Please ask for: Nicola Moore
Email: nicola.moore@arun.gov.uk
Telephone: Ext 37944
Our Ref: AL/83/21/PL
Your Ref:
Date: 7th July 2021

Application for Planning Permission

Development: Conversion of existing storage building & garage to 1 No. 3 bed dwelling. including new access to existing dwelling. This application is in CIL Zone 2 and is CIL liable as new dwelling.

Location: Land Adj To 1 Hook Lane Westergate PO20 3QL

PROPOSED GROUND FLOOR
PLAN scale 1:100

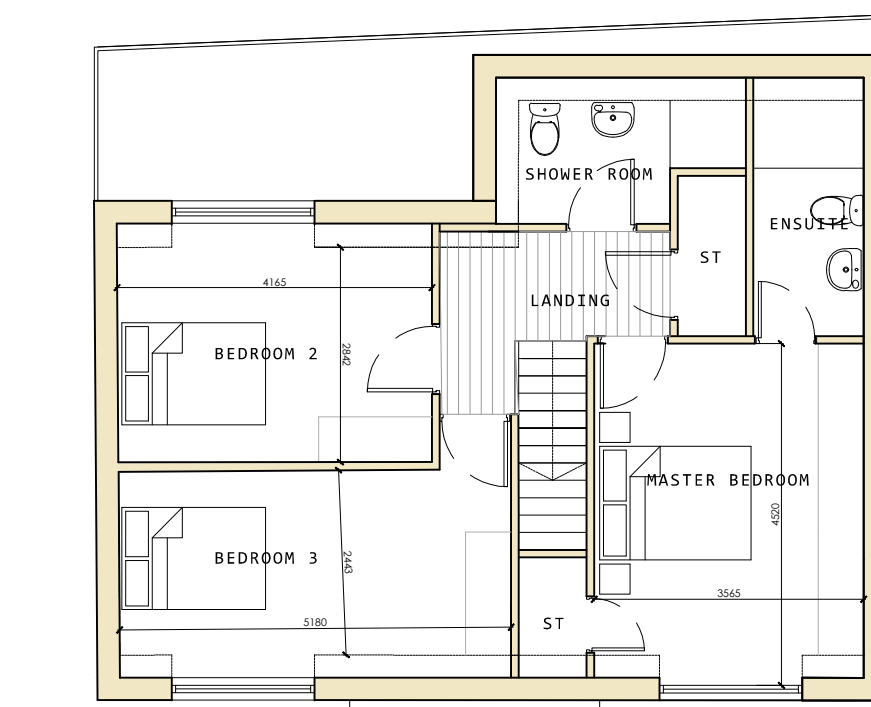
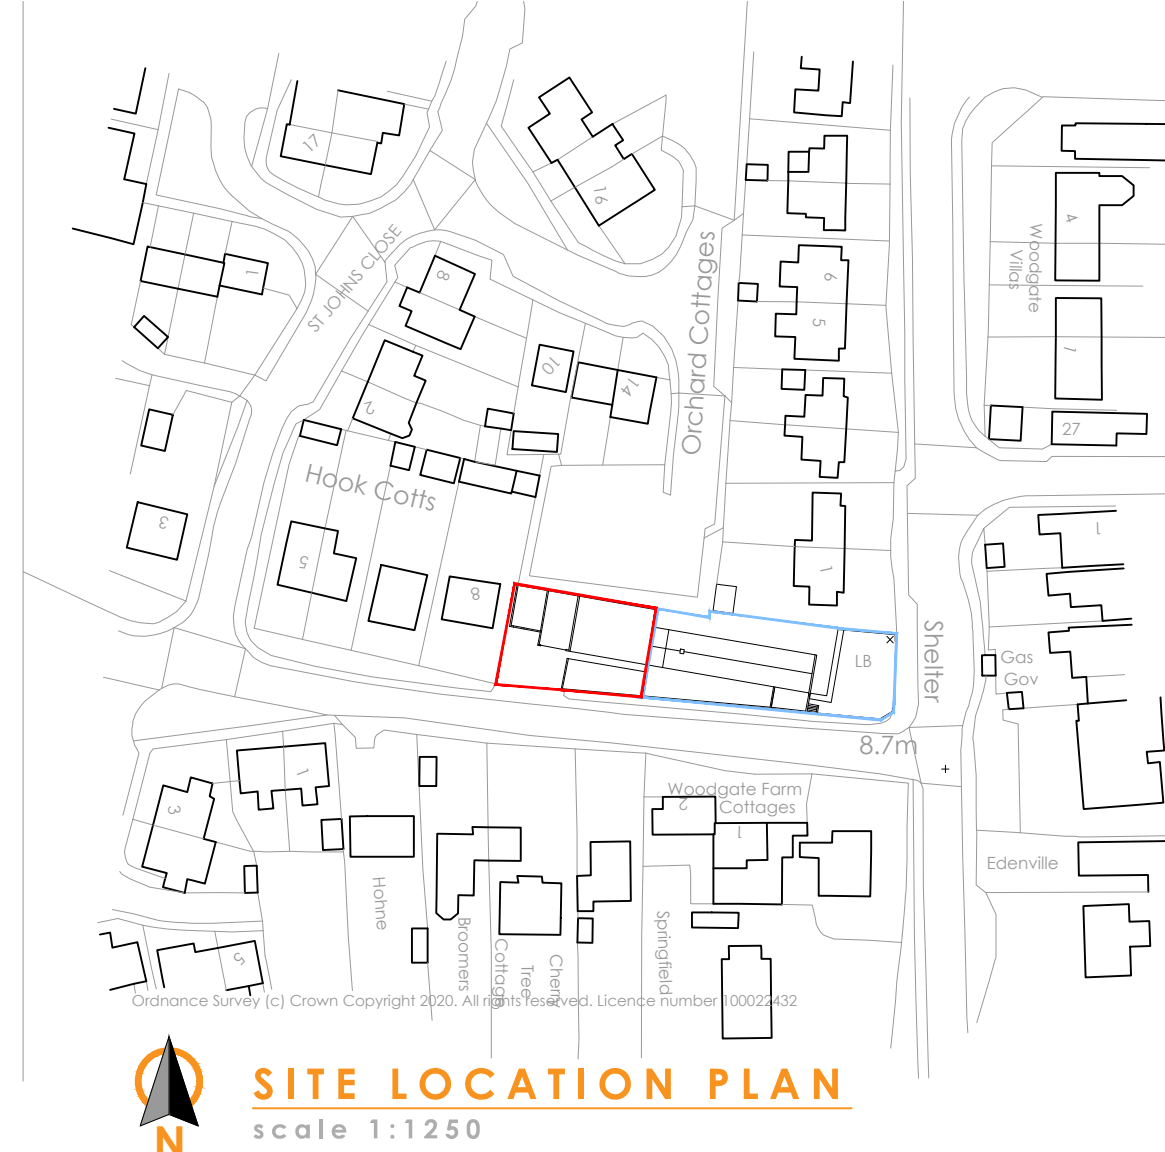
For clarity please confirm the number of bedrooms, as the application form shows 2 bed and the floor plan shows 3 bedrooms
